My ref: DC/RP/2010/0673

Date: 24 June 2010

RE: Erection single storey side extension 22 Riber Avenue, Athersley South, Barnsley

PROPOSED FRONT ELEVATION

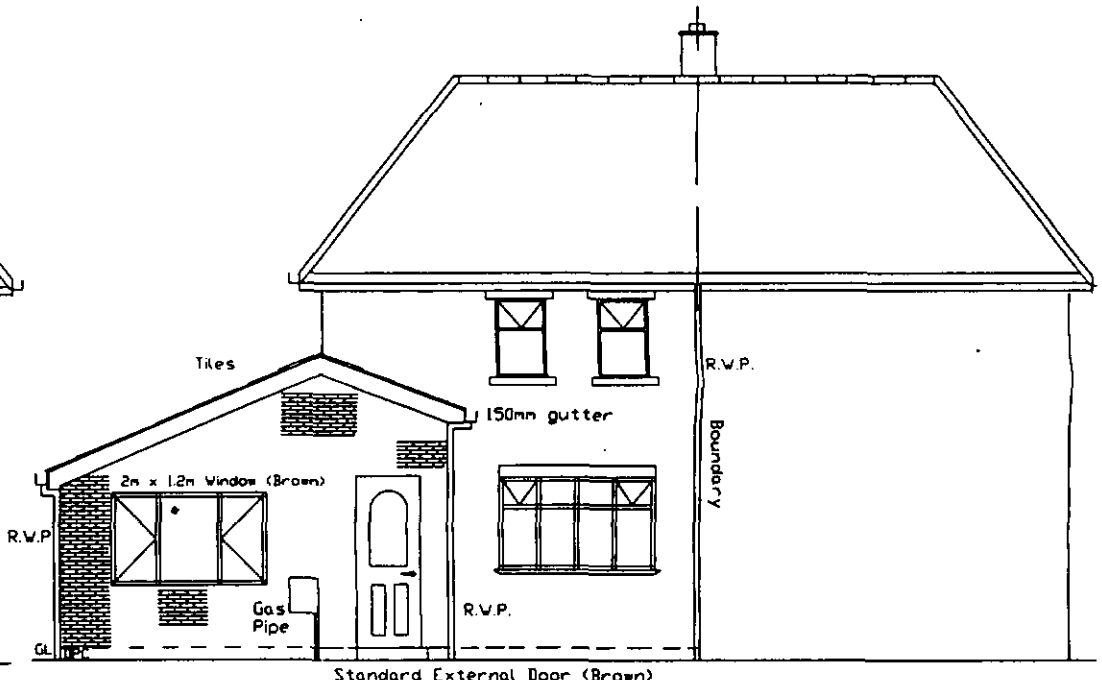
It is important that all domestic extensions are designed so that they are in keeping the host property and the character of the wider street scene. In this regard it is considered that the proposal represents an overbearing feature which would detract from the appearance of the property and not appear sub-servient to ensure the original dwelling remains the dominant feature.

It is considered that a more satisfactory form of development would be to reduce the sideways projection of the proposal to 3.5m and to alter the design of the lean too roof.

As a consequence of the above I urge you to submit amended plans incorporating the reduction in projection and alterations to the roof design, within 10 working days from the date of this letter. Please mark it for the attention of Rachael Pell and send it to the above address, otherwise a decision will be made based on the scheme which is before me.
